One Earth Solar Farm

**Draft Statement of Common Ground with Historic England
EN010159/APP/8.7**

July 2025

ILLUS 4 Area 2 SE site map

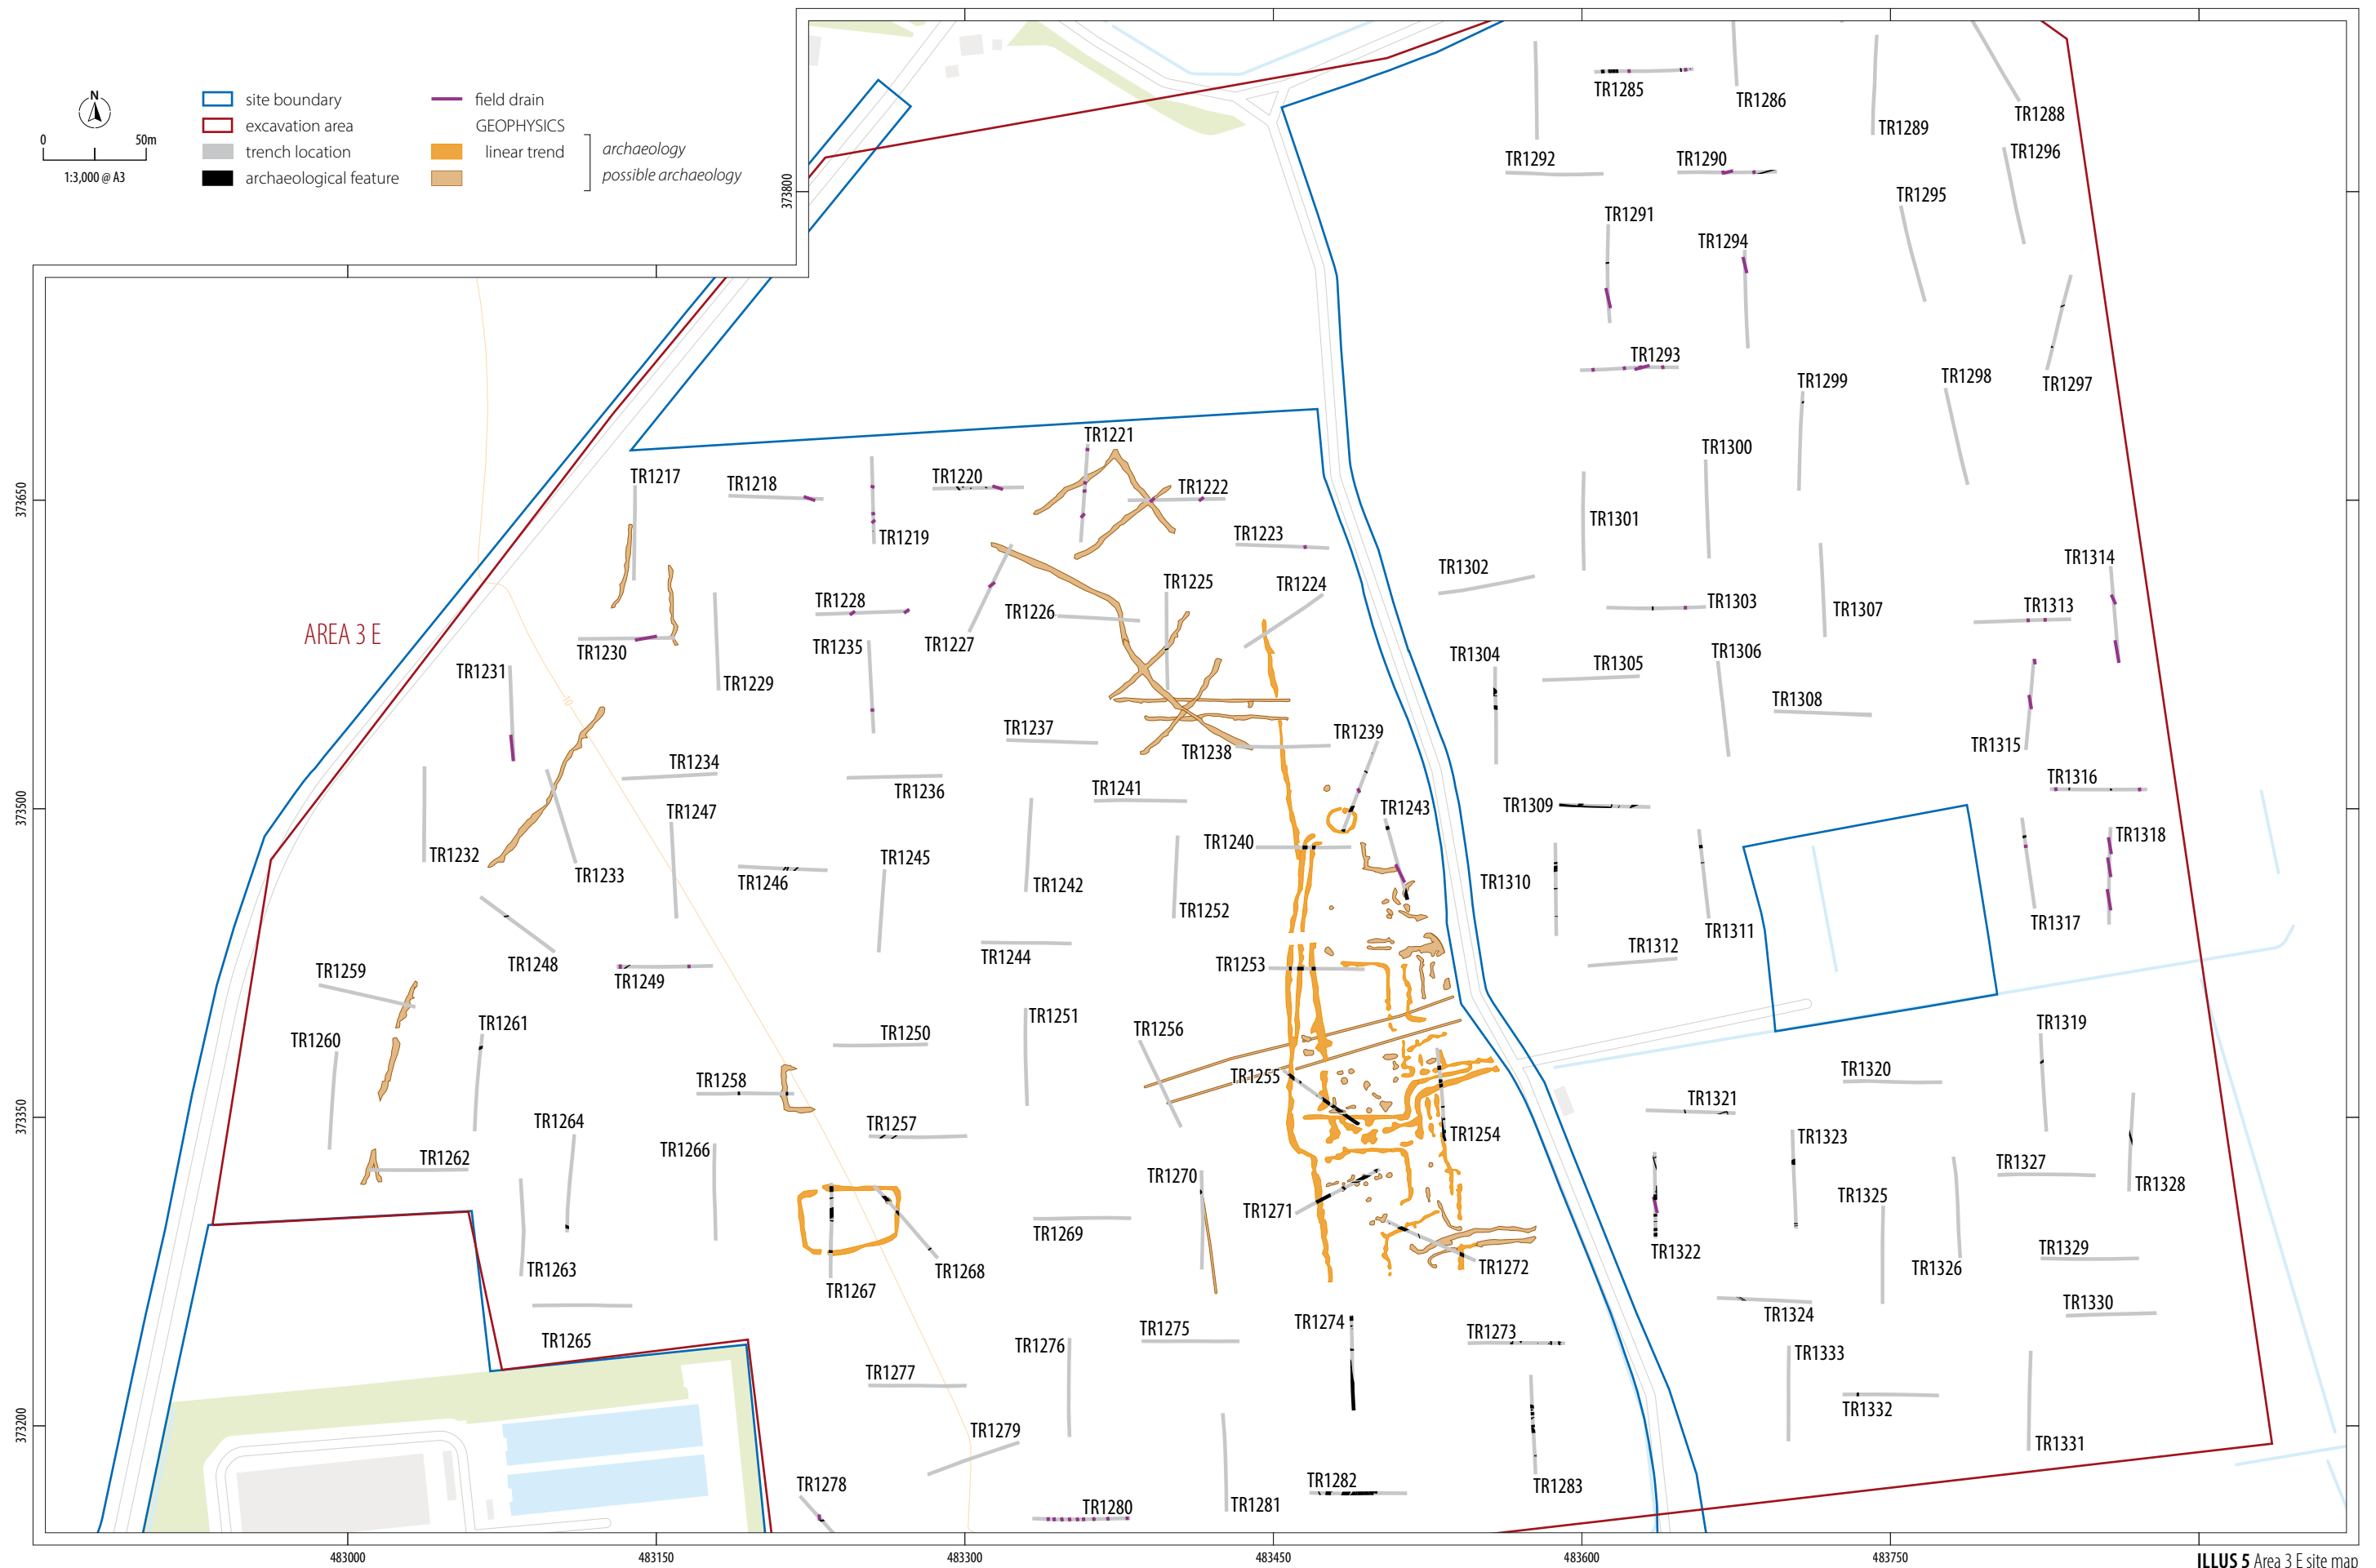
Ref.	Description of Matter	Stakeholder Comment	Applicant's Response	Status
02-01	Impacts on buried heritage assets	<p>Historic England raise concerns regarding the proximity of the panels to the west and south of the reservoir, due to the potential for archaeological deposits in this area associated with the Roman Fort Scheduled Monument.</p> <p>Further detail can be found in Historic England's Statutory Consultation Response in July 2024, and in Relevant Representation [RR-019], as well as email correspondence in December 2024 – January 2025.</p>	<p>Further detail can be found in the Archaeological Desk-Based Assessment [APP-110 to APP-115] at paragraph 5.11.3, and in the Preliminary Results of the Trial Trenching [APP-124]. An assessment of the potential impact on archaeological deposits south of the water reservoir has been carried out in Chapter 9: Buried Heritage [APP-038] at 9.6.82-87.</p> <p>The DBA and geophysical survey detected potential buried heritage assets south of the water reservoir. The areas have been evaluated via trial trenching in March 2025, and the results of the evaluation will be submitted alongside the draft Outline Written Scheme of Investigation (oWSI), along with the</p>	Under Discussion
